# CITY OF ALBUQUERQUE

June 29, 2007

**Re: Milligan Duplex Grading and Drainage Plan**  
**Engineer's Certification Stamp dated 6-29-07, (J11/D34)**

GRADING AND DRAINAGE PLAN

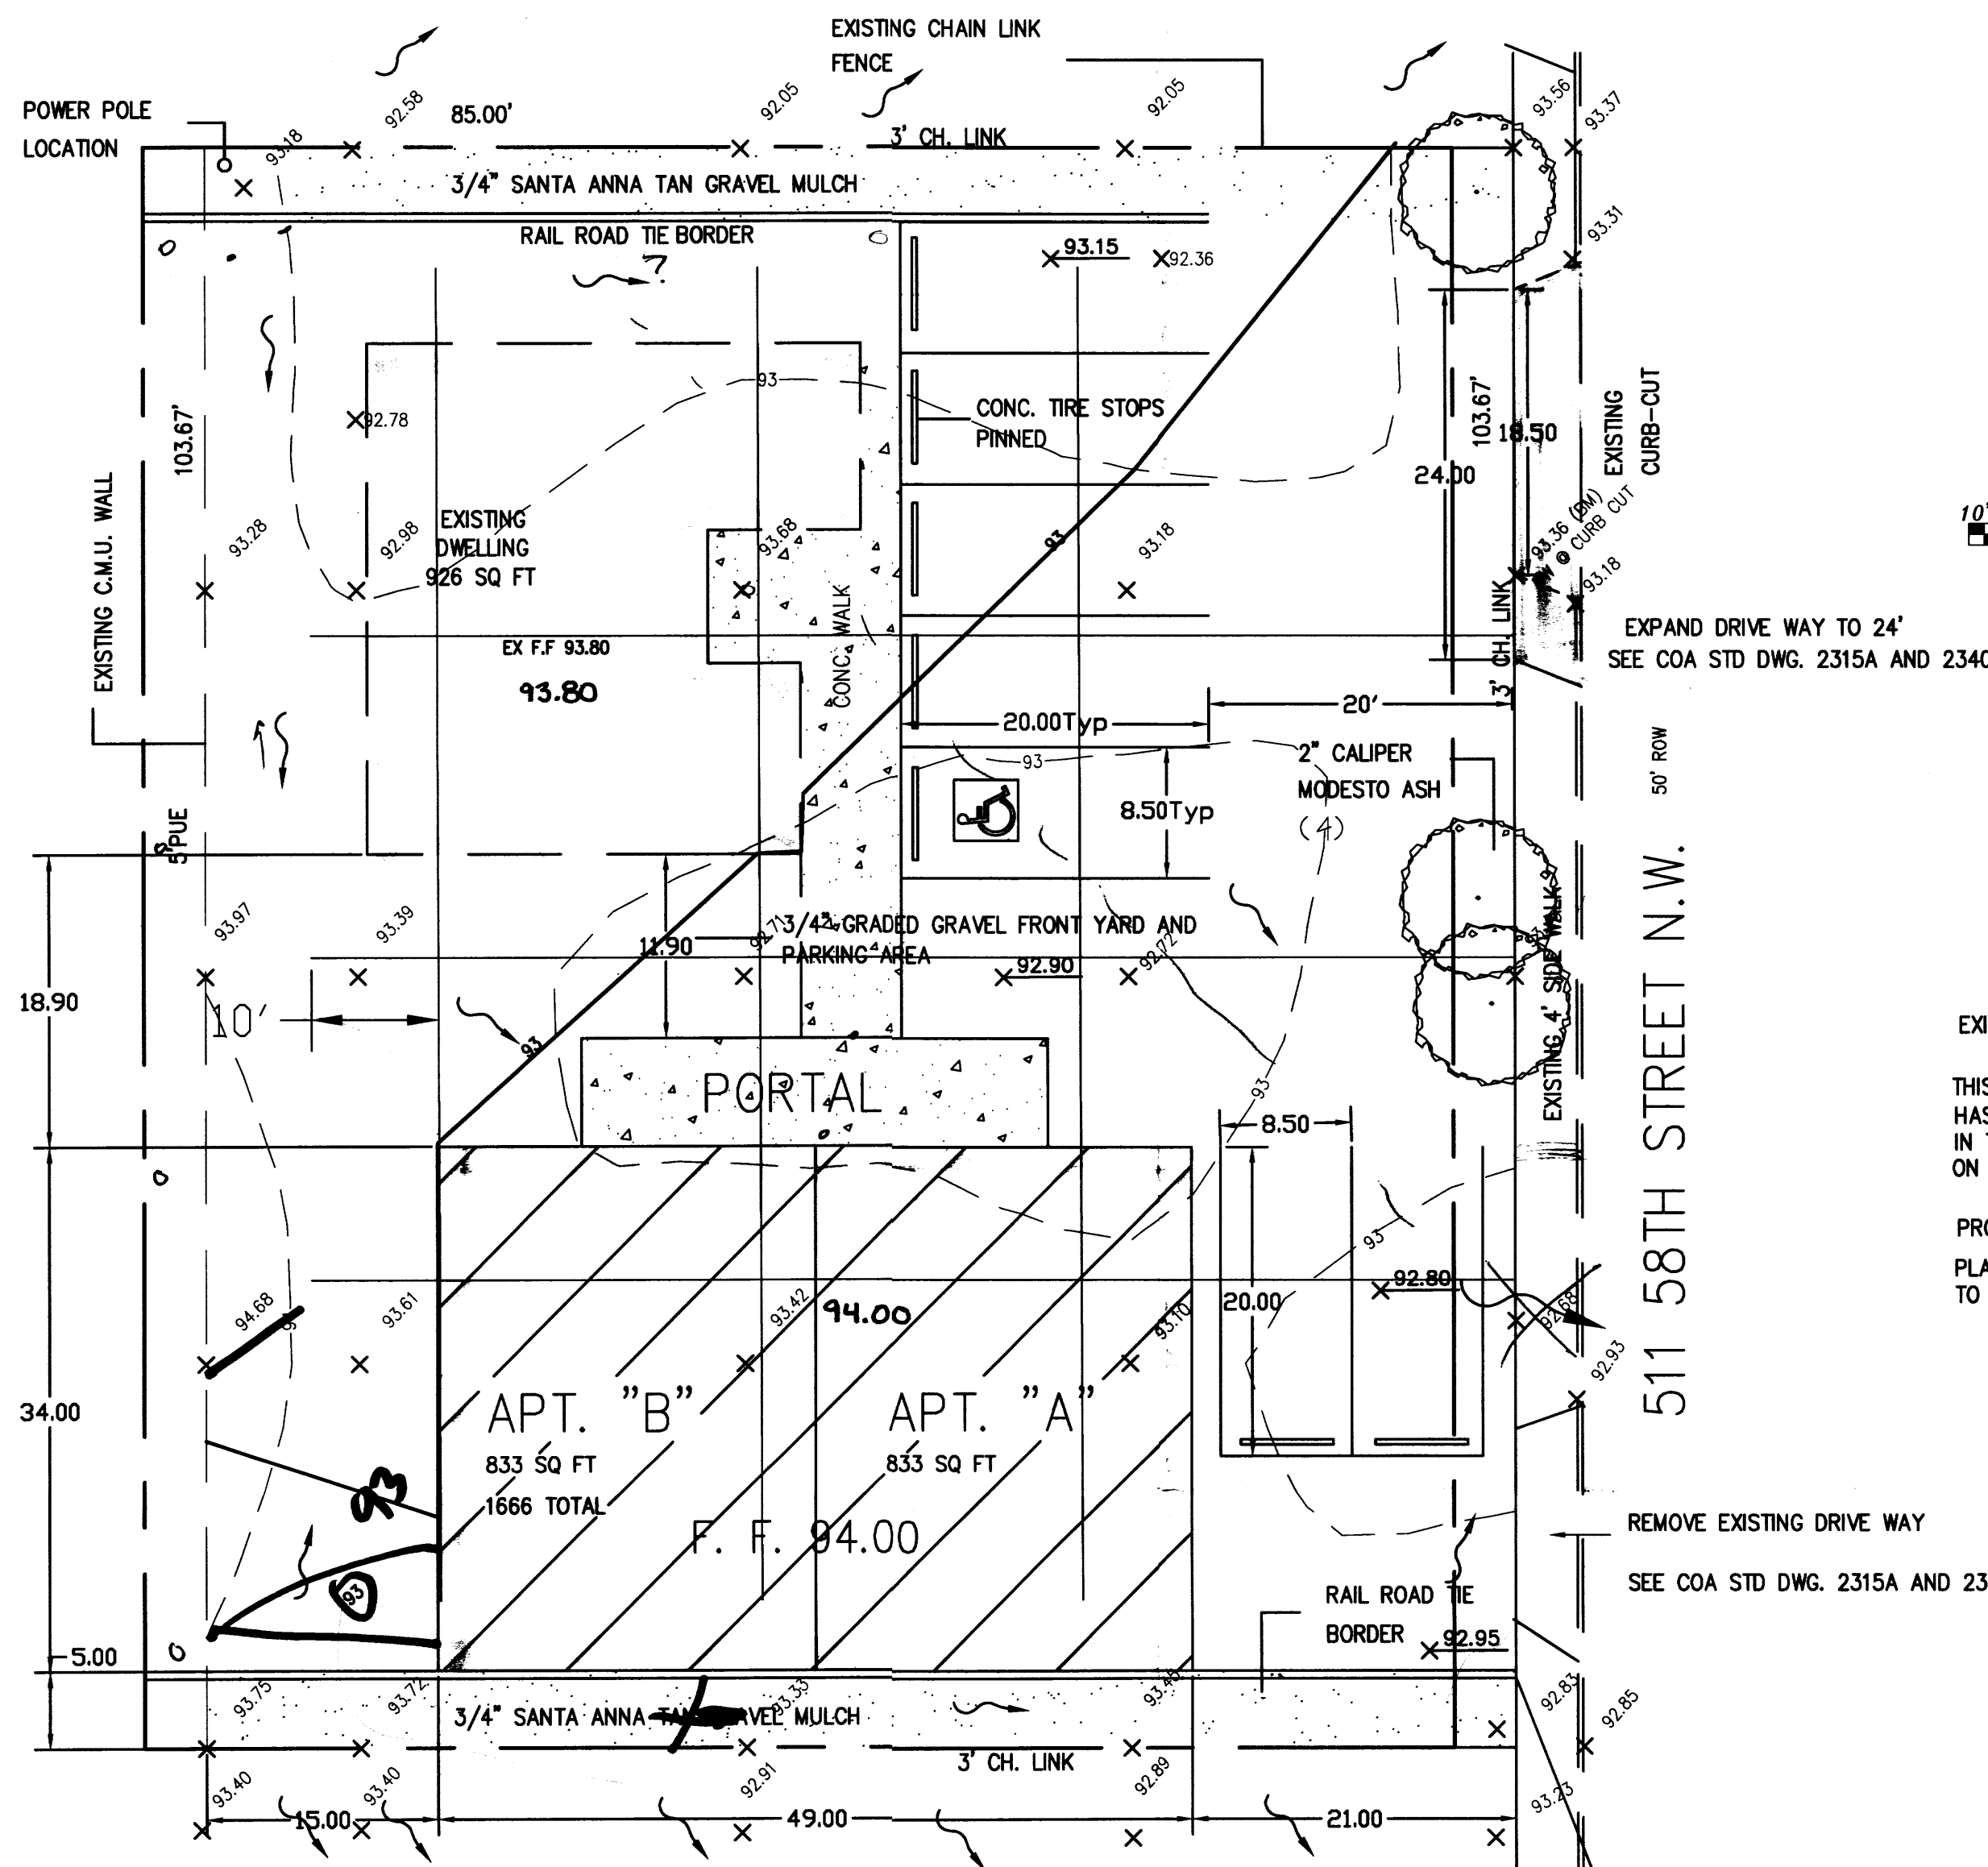
Based upon the information provided in your submittal dated 6-29-07, the above referenced plan is approved for Building Permit and SO#19 Permit. Please attach a copy of this approved plan to the construction sets prior to sign-off by Hydrology.

Also, prior to Certificate of Occupancy release, Engineer Certification of the grading plan per the DPM checklist will be required.
